Re: WCF23-006 (Dish Wireless Collocation)
Request for Information #1
8477 SE 68th St

Address: 8477 SE 68th Street, Mercer Island, WA 98040
Crown Castle Site Number: 880416
Carrier Site Number: SESEA00010B

Below are Power of Design's responses to the plan check comments in [blue](#):

A-2.1

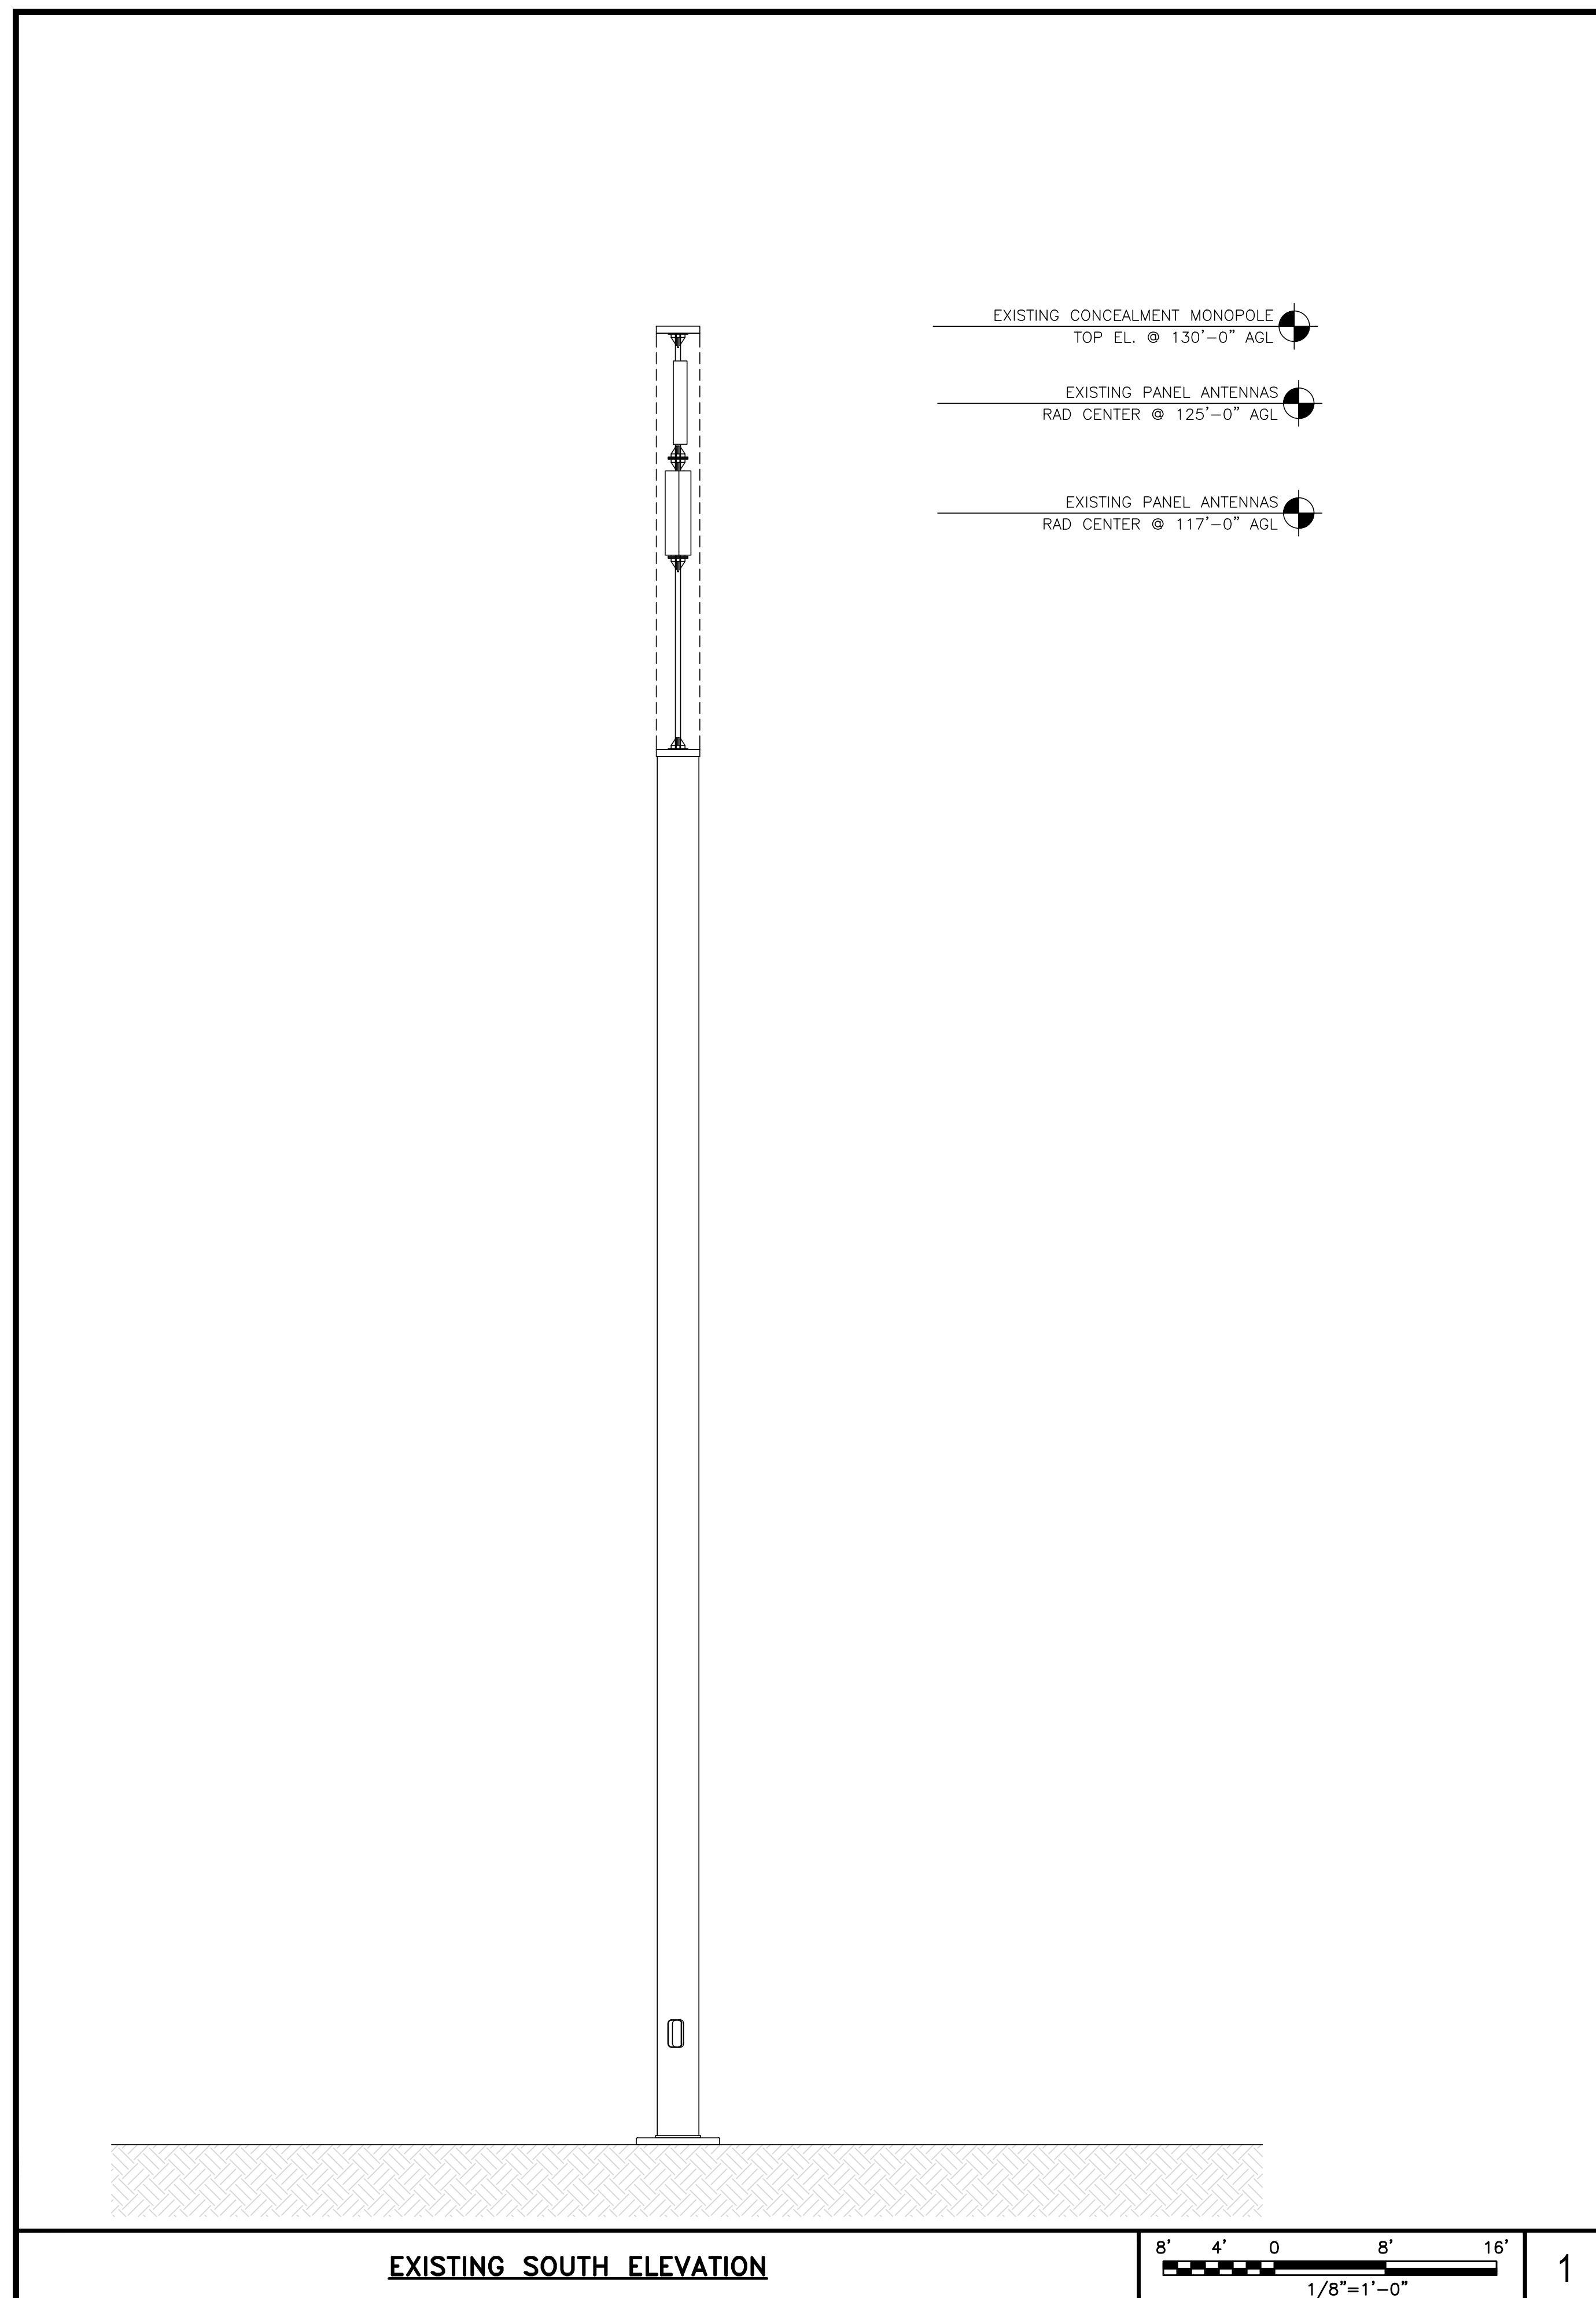
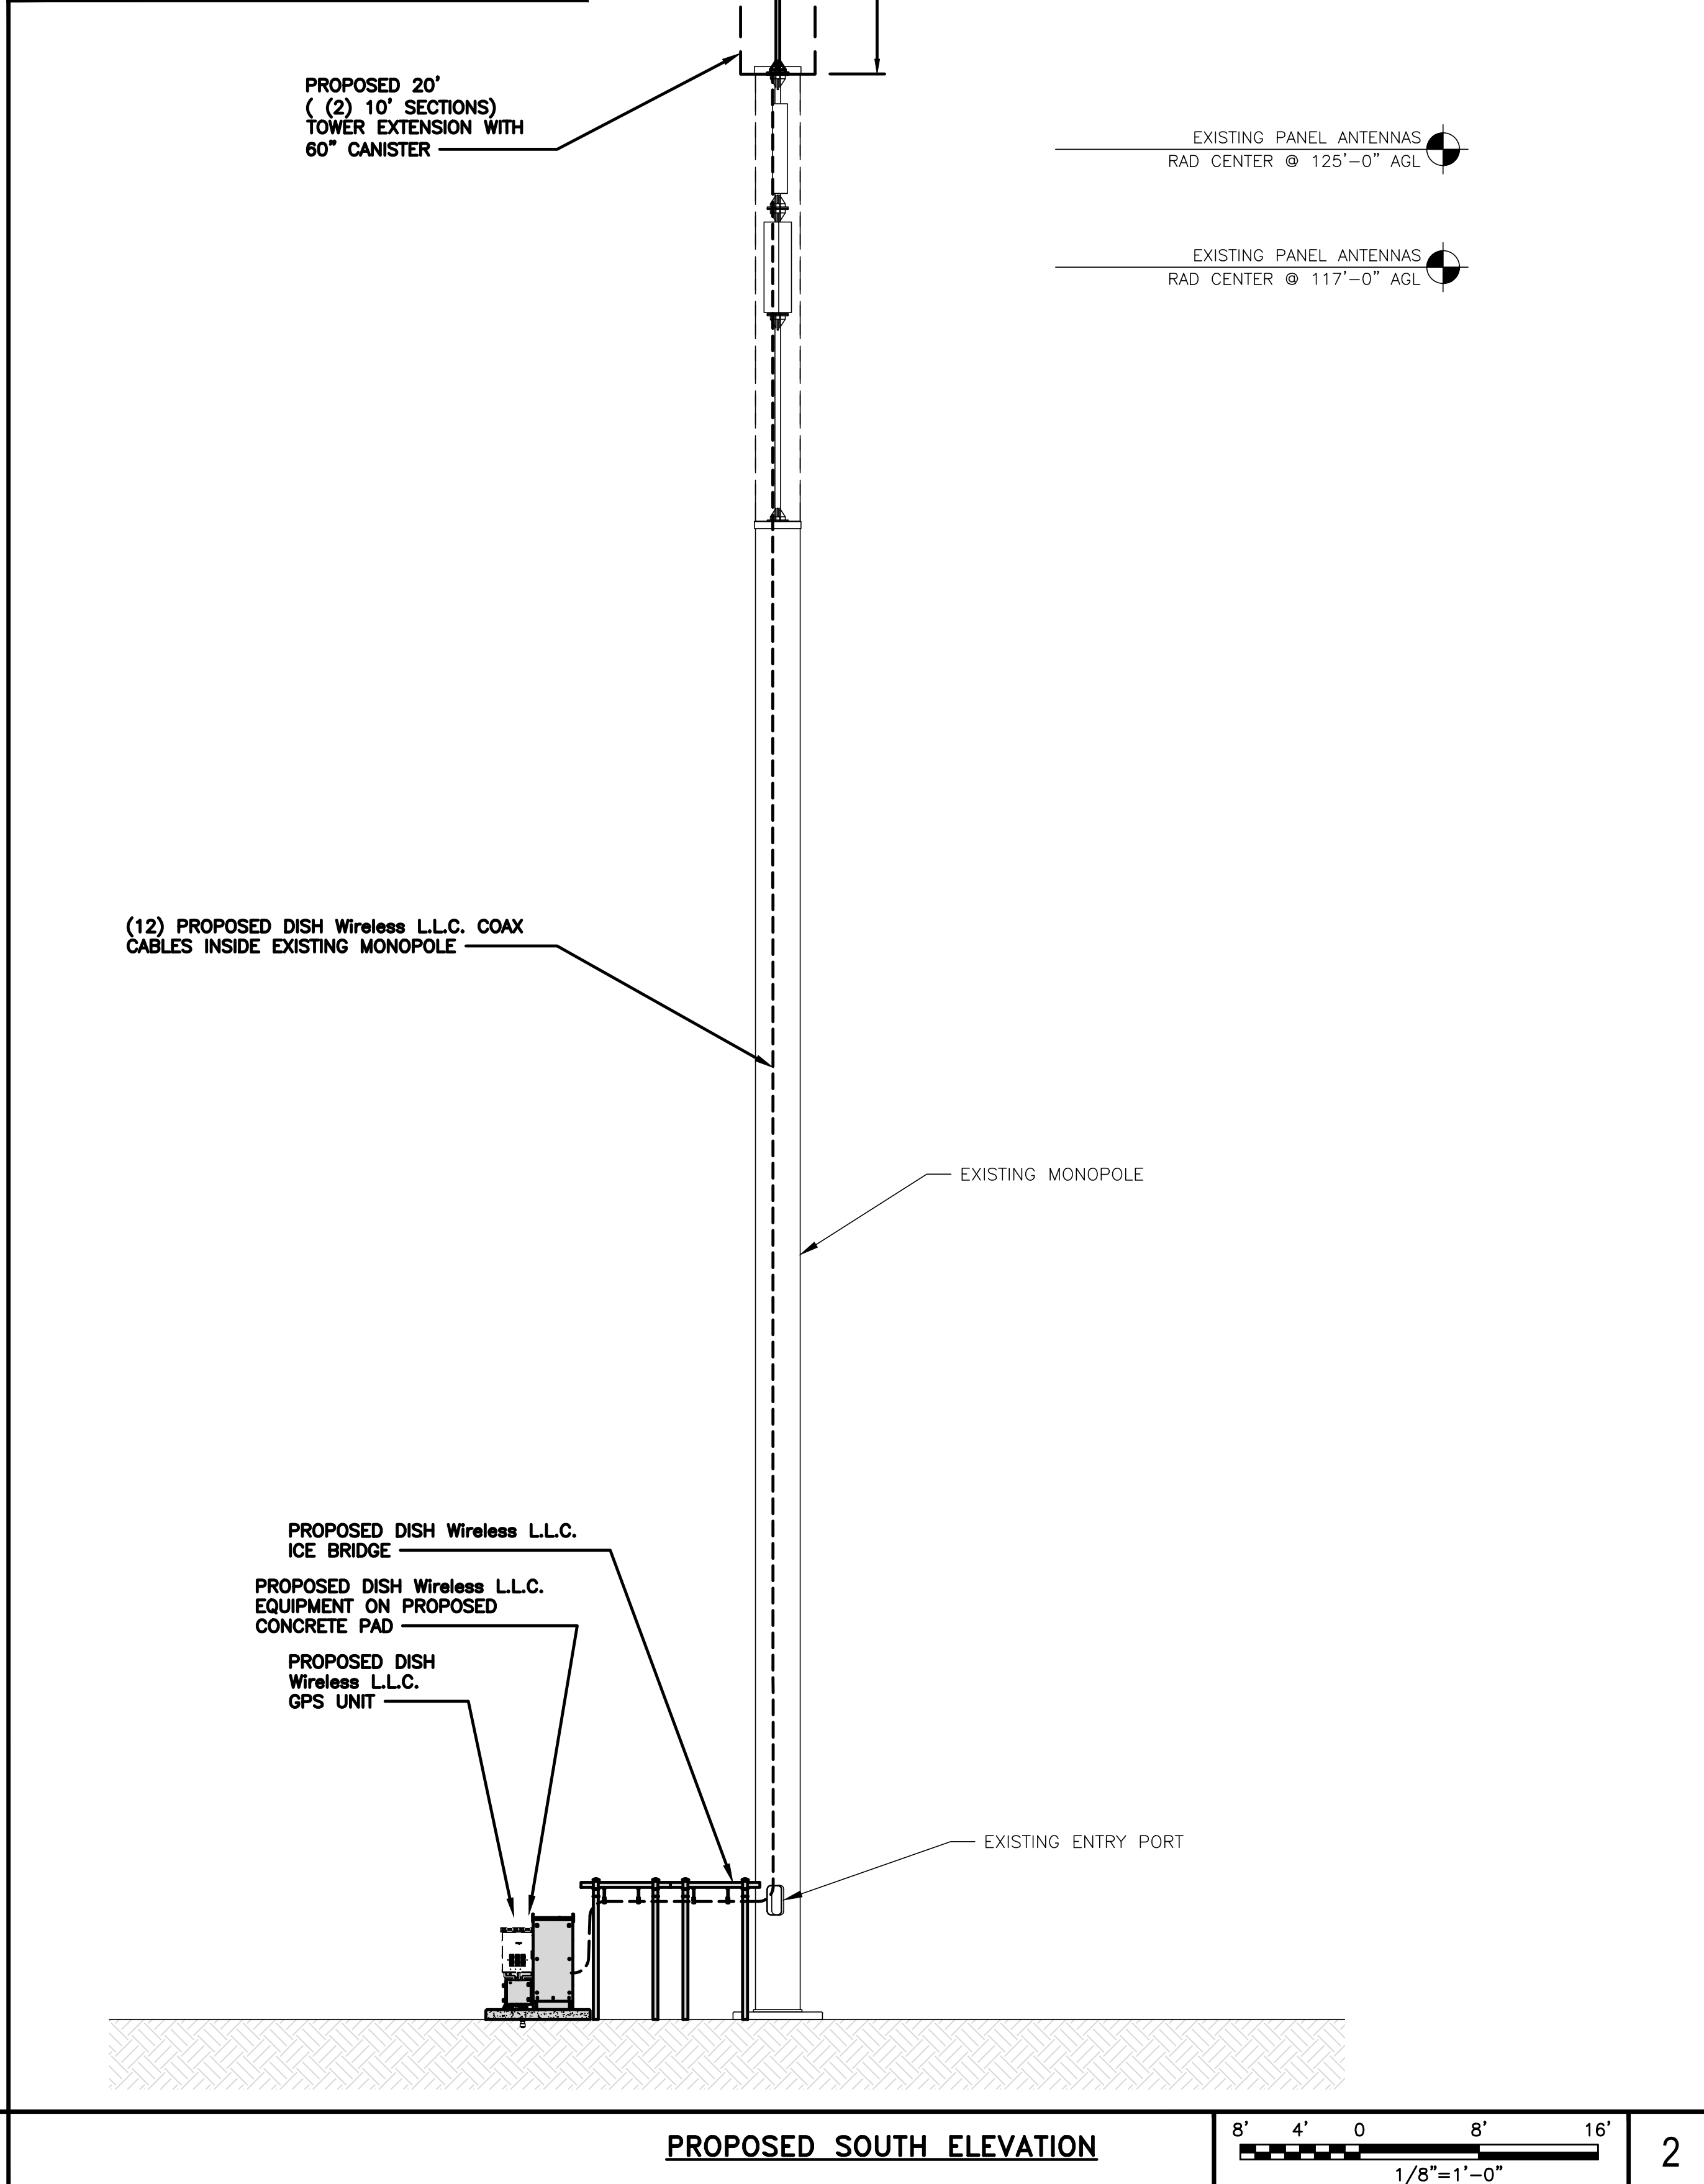
1. MICC 19.06.040(E)(2) requires WCFs with support structures to blend into the existing site, including using colors to match new equipment to the existing equipment. Please confirm that the proposed tower extension will be colored to match the existing structure.
– [Installer notes "NEW EQUIPMENT AND TOWER EXTENSION TO BE PAINTED WITH RF TRANSPARENT, UV RESISTANT, OUTDOOR RATED PAINT TO MATCH EXISTING." have been added to the elevation and antenna layout sheets A-2.1 and A-2.2.](#)
